# TRANSPORT FOR LONDON

## M25 JUNCTION 28 IMPROVEMENTS – WRITTEN SUMMARY OF ORAL SUBMISSIONS MADE AT ISSUE SPECIFIC HEARING 3

20 MAY 2021

TRAFFIC MANAGEMENT LAYOUT 1
A12 EASTBOUND LANE 1 CLOSURE
IN ADVANCE OF EXIT SLIP

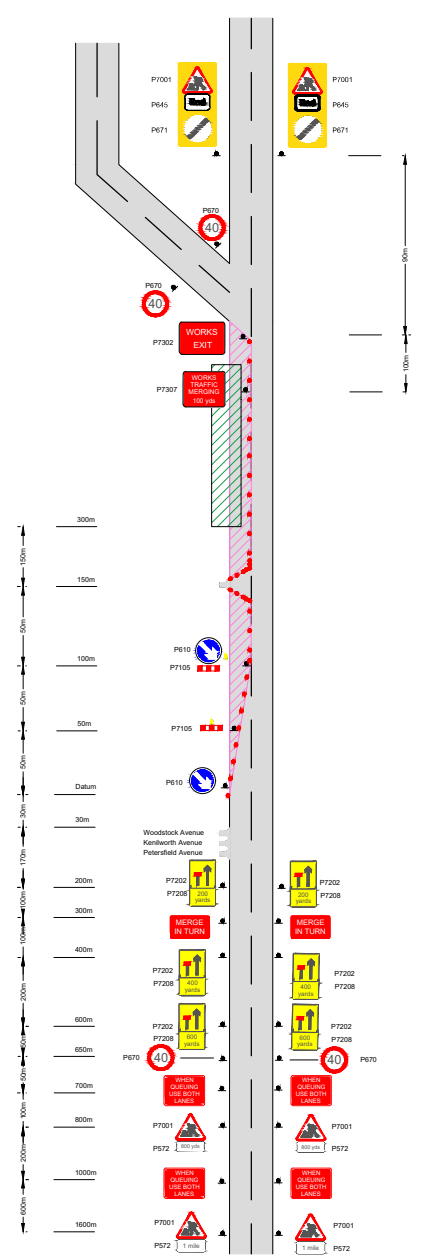
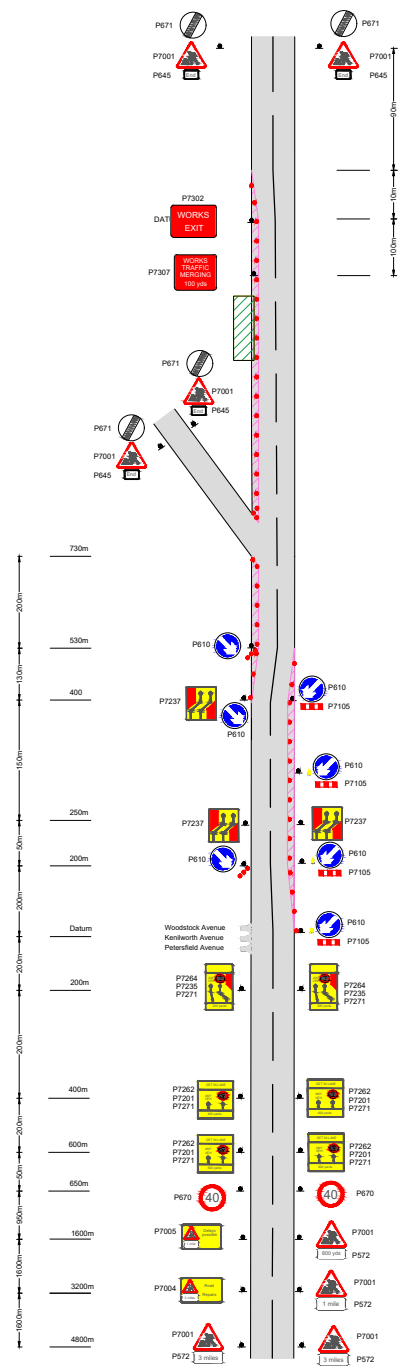
- 2.2.3 The second point raised by TfL was over the temporary lane closures on the A12 eastbound carriageway set out in the outline TMP, with lane 1 of the eastbound A12 carriageway forecast to be closed for approximately 1.8 km during off peak periods for a total of 141 days over a seven-month period for statutory undertakers diversions (reference REP4-013 Table 2-4). TfL was concerned that the modelling of the construction period set out in the Transport Assessment Supplementary Information Report (TASIR) was inconsistent as the Applicant did not mention that interpeak closures of one lane of the eastbound A12 had been modelled. However, the Applicant made clear in its comments on TfL's responses to the ExA's Further Written Questions (reference REP6-011 question TA 2.4 paragraph 4.2) that the modelling reported in the TASIR had in fact included closures of one lane of the eastbound A12 in modelling for the interpeak period despite this not being specified in the TASIR. On this basis TfL has been reassured on this matter and has no further concerns, as the modelling in the TASIR shows that the off peak lane closure is not forecast to have any substantial adverse impacts on traffic flows or delays.

- 2.2.4 Thirdly, TfL has raised concerns about the narrow lane running required on the A12 eastbound carriageway, and in particular the comment in the outline TMP that the narrow lanes required may increase potential hazards to pedestrians and therefore nearside lane closures of the A12 may be necessary instead (reference REP4-013 paragraph 2.3.14). This would have been of great concern to TfL because lane closures on the A12 carriageway during peak periods would have substantial adverse impacts on traffic flows and delay. The Applicant subsequently set out that the narrowing of lanes would be towards the central reservation and a protective barrier for pedestrians would be provided (reference REP6-011 question TA 2.4 paragraph 4.5) therefore no lane closures of the A12 carriageway would be required at peak times. TfL stated at the hearing that the outline TMP should be updated accordingly to specify that lane closures on the A12 eastbound carriageway at peak times will not be necessary. The Applicant agreed to make this change.

TRAFFIC MANAGEMENT LAYOUT 3
A12 EASTBOUND EXIT SLIP
NEARSIDE LEFT TURN LANE CLOSURE

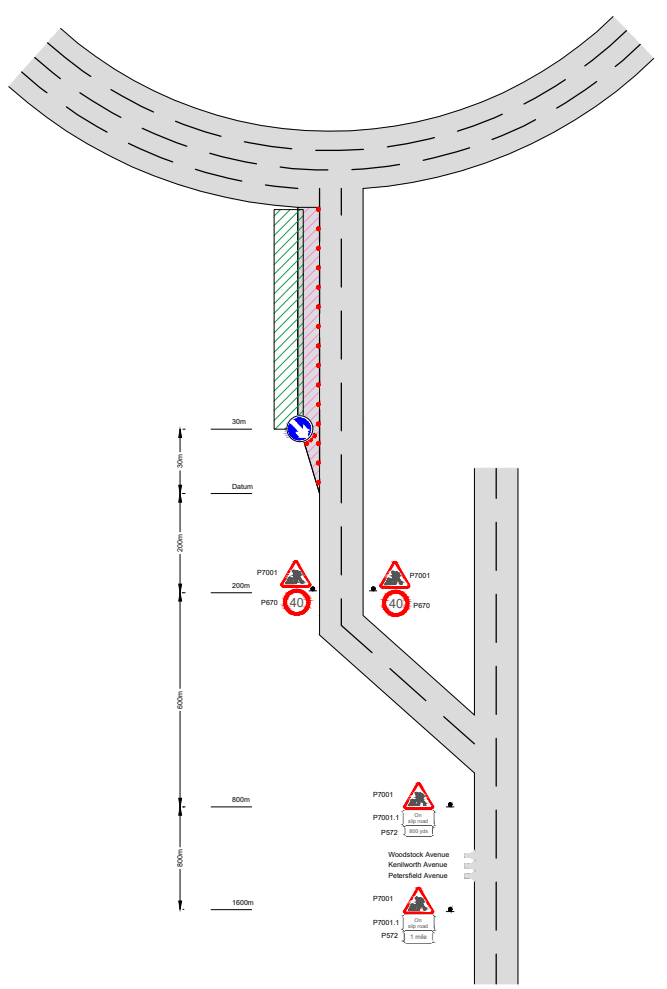
- 2.2.5 The final point TfL raised on the outline TMP was on a related matter, concerning the Applicant's comments on TfL's responses to the ExA's Further Written Questions which specified that the footway along the A12 eastbound off slip will need to be closed for an extended period during construction (reference REP6-011 question TA 2.4 paragraph 4.5). The Applicant explained at the hearing that pedestrians on the north side of the A12 would need to walk west towards London to use the subway under the A12 at the junction with Petersfield Avenue to access the footway on the south side of the A12 during this time. TfL made clear at the hearing that this footway closure would need to be carefully managed with appropriate signage and other measures in place to reduce the risk of pedestrians trying to cross the A12 carriageway at non-designated locations. TfL perceives this to be a risk because of the length of the diversion route for pedestrians. The Applicant stated that it considers this to be a detailed matter for the TMP rather than suitable for inclusion in the outline TMP. TfL considers that while detailed measures to be put in place do not need to be included in the outline TMP, principles about how pedestrian diversions to be managed to reduce safety risks for both pedestrians and traffic should be included.
